Submission

SSD-17424905 – 20 Avon Road, Pymble

4 December 2021

Client: Owner of 57A Pymble Avenue, Pymble
Subject land: 20 Avon Road, Pymble
Lot Description: Lot 1, Deposited Plan 69541
Local Government Area: Ku-ring-gai Council
Project Title: Grey House Precinct, Pymble Ladies College
Project Description: The redevelopment of the Grey House Precinct within the grounds of the established College.

SHADOW DIAGRAMS -
SHEET 3

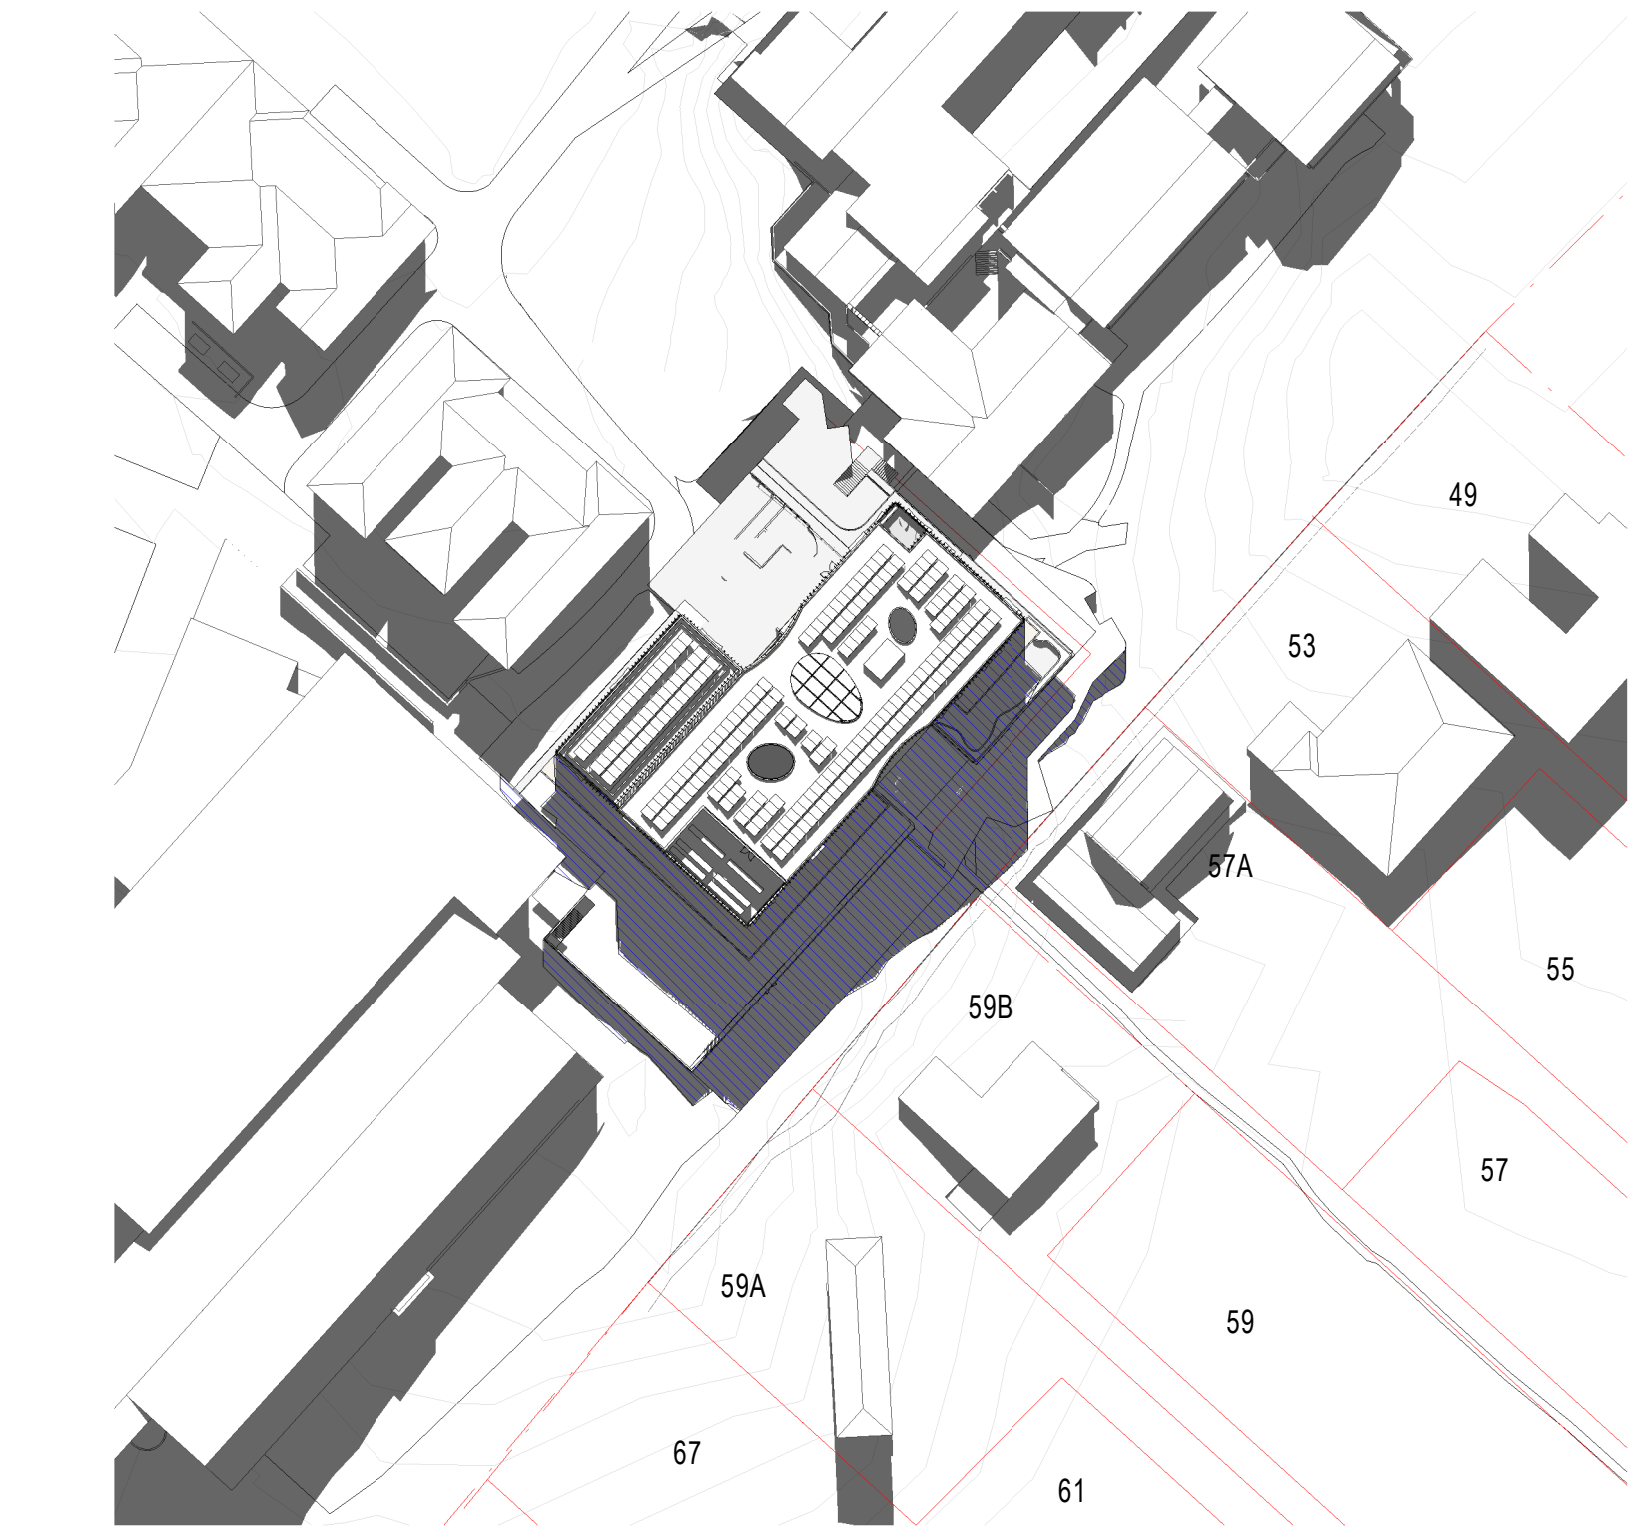
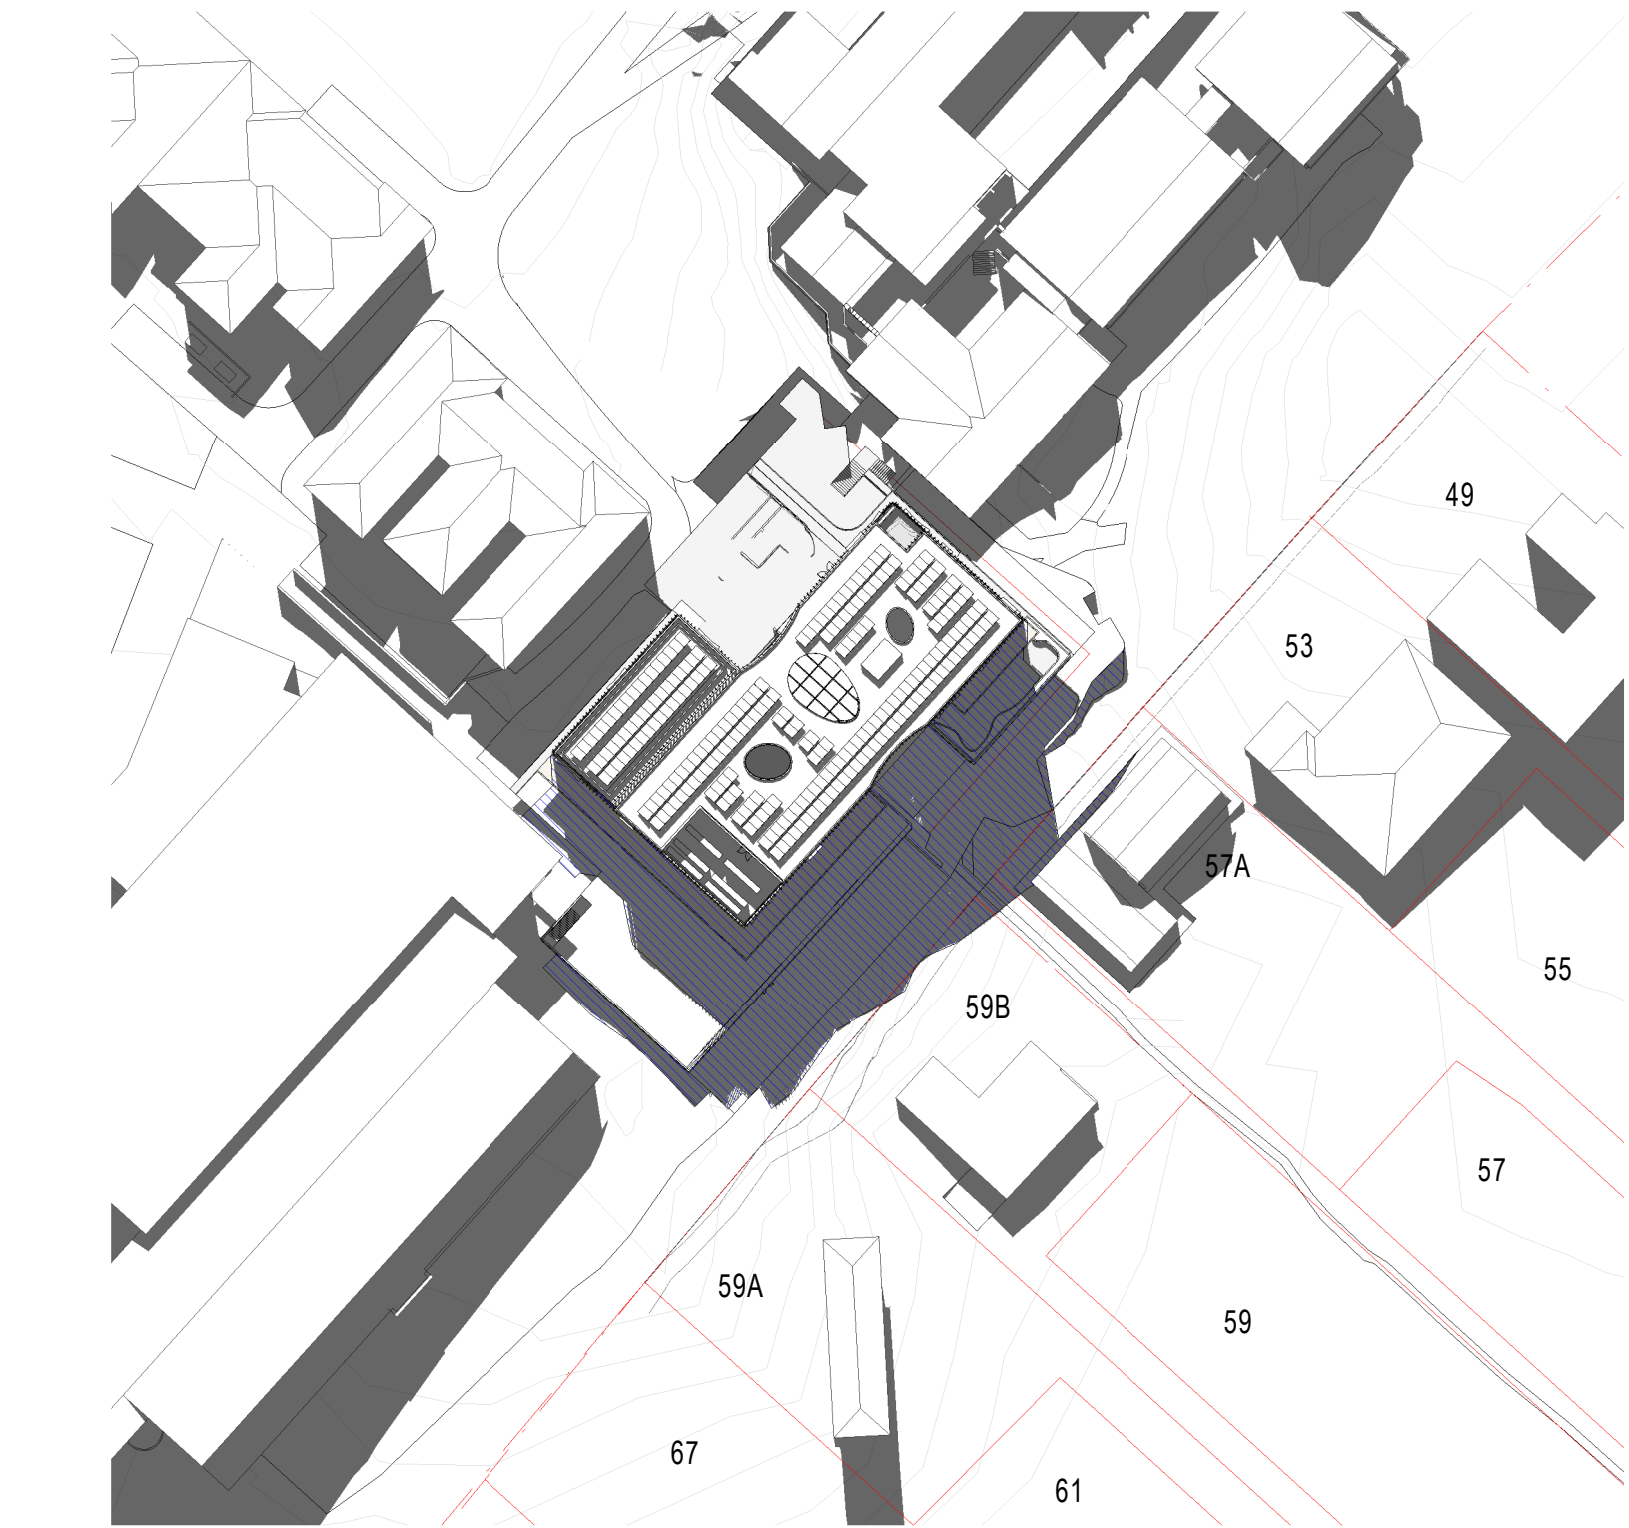
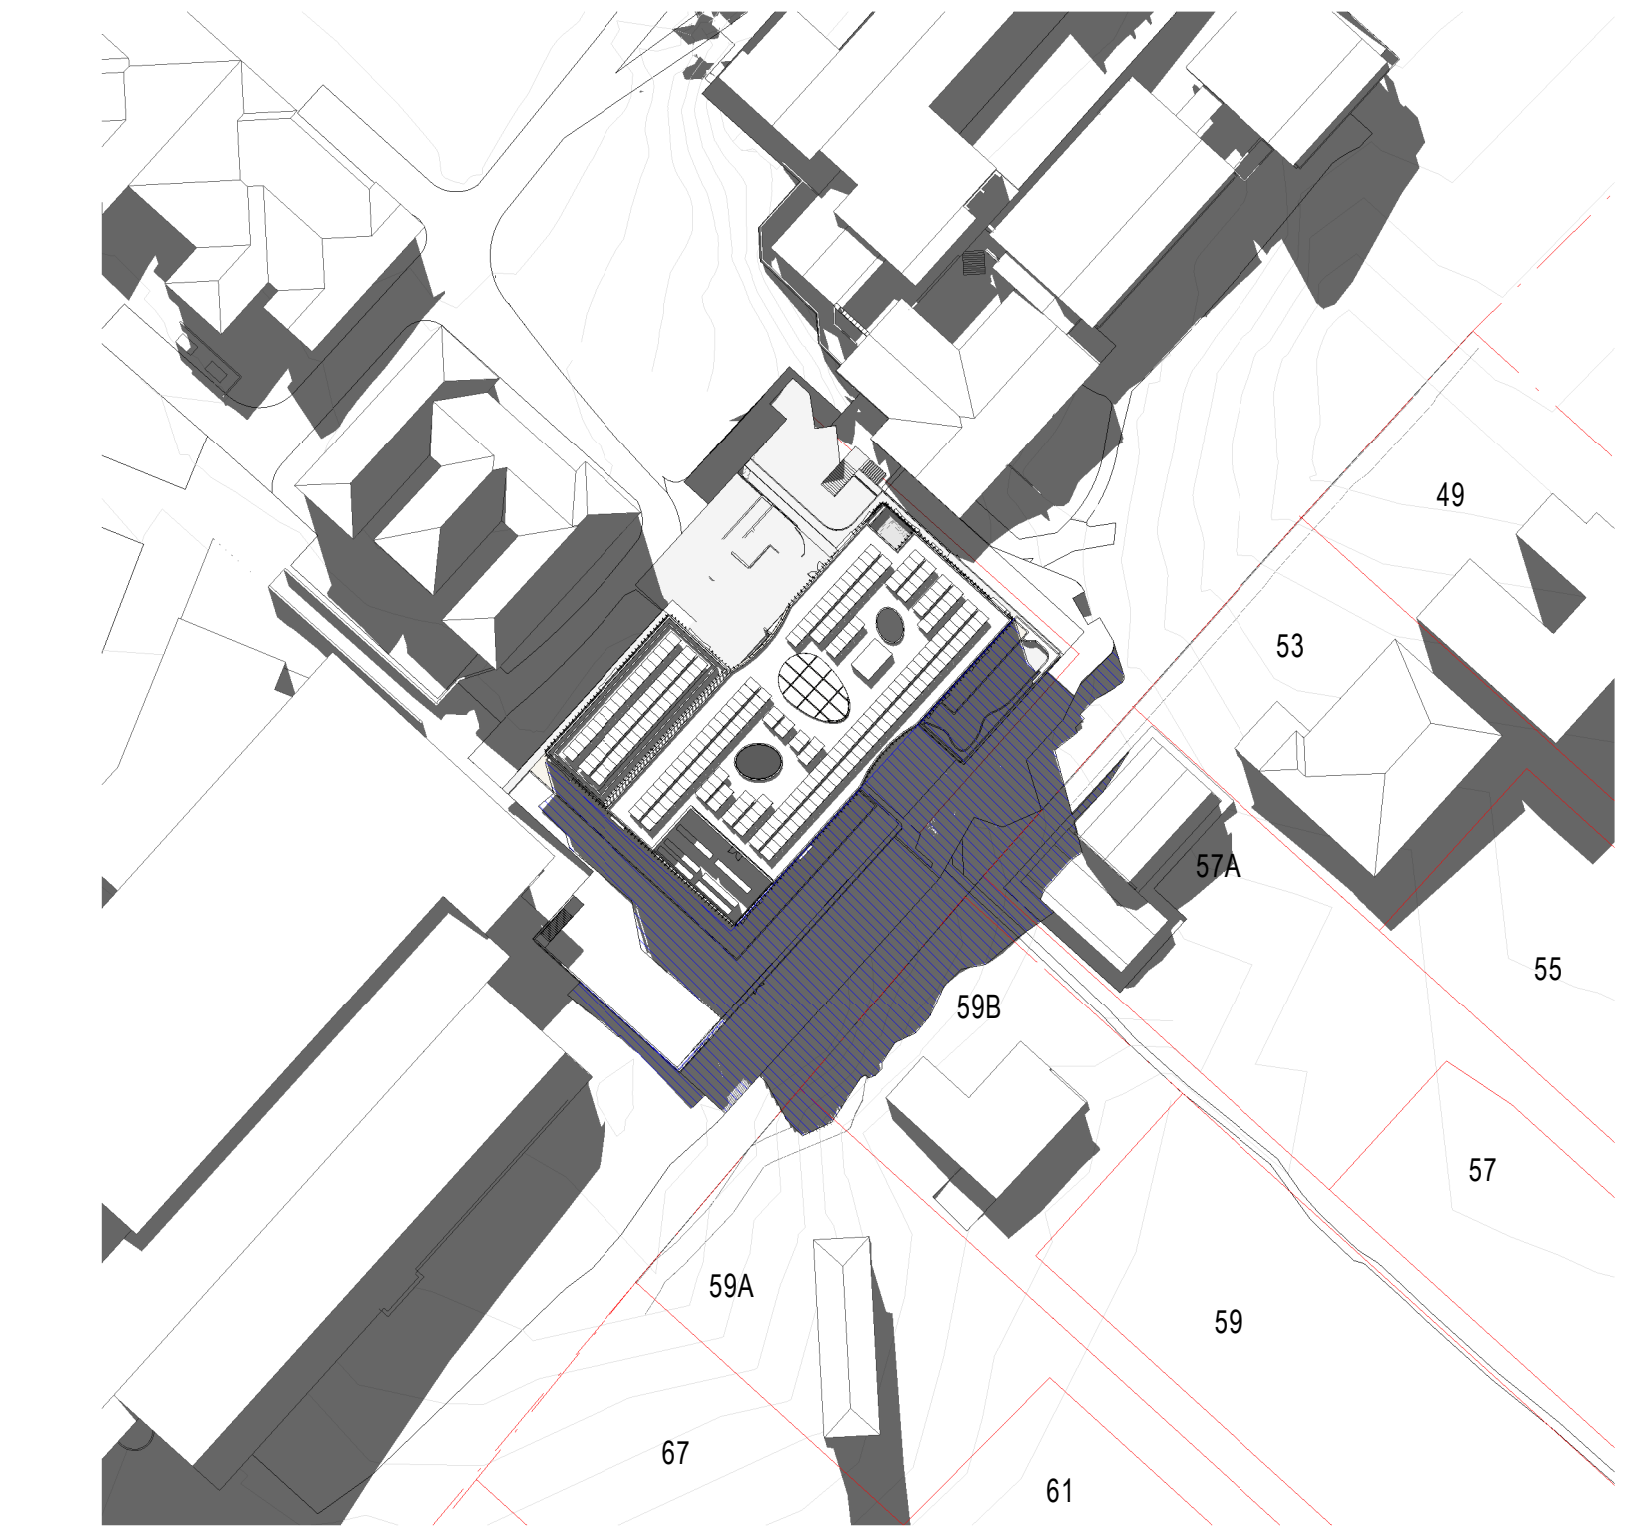
The works proposed under SSD-17424905 will substantially decrease the amount of sunlight received by the PPOS and primary living rooms of 57A Pymble Avenue from midday onwards. As per the proposed shadow diagrams shown in figures 3 and 4, there is severe overshadowing by the

Grey House building throughout the entire afternoon, caused by the minimal proposed southern setback, substantial scale and bulk, and the sloping terrain which naturally elevates the development site.

The above example is identical to the circumstances imposed by SSD-17424905 on the rear garden and north-facing internal living area of 57A Pymble Avenue, Pymble. As highlighted within the shadow diagrams prepared by BVN Architecture dated September 2021 in figure 4, the proposal will block significant sunlight from midday onwards. **This will have a detrimental impact on the current and future residents, and cannot be supported.**

- e) **Action:** Prepare shadow diagrams considering the maximum mature height and spread of the proposed trees between the Grey House building and 57A Pymble Avenue. Plantings should offer privacy without providing additional shadow for No. 57A.
Outcome: To ensure that privacy mitigation measures (ie. proposed landscape screening) does not sacrifice solar access for 57A Pymble Avenue.
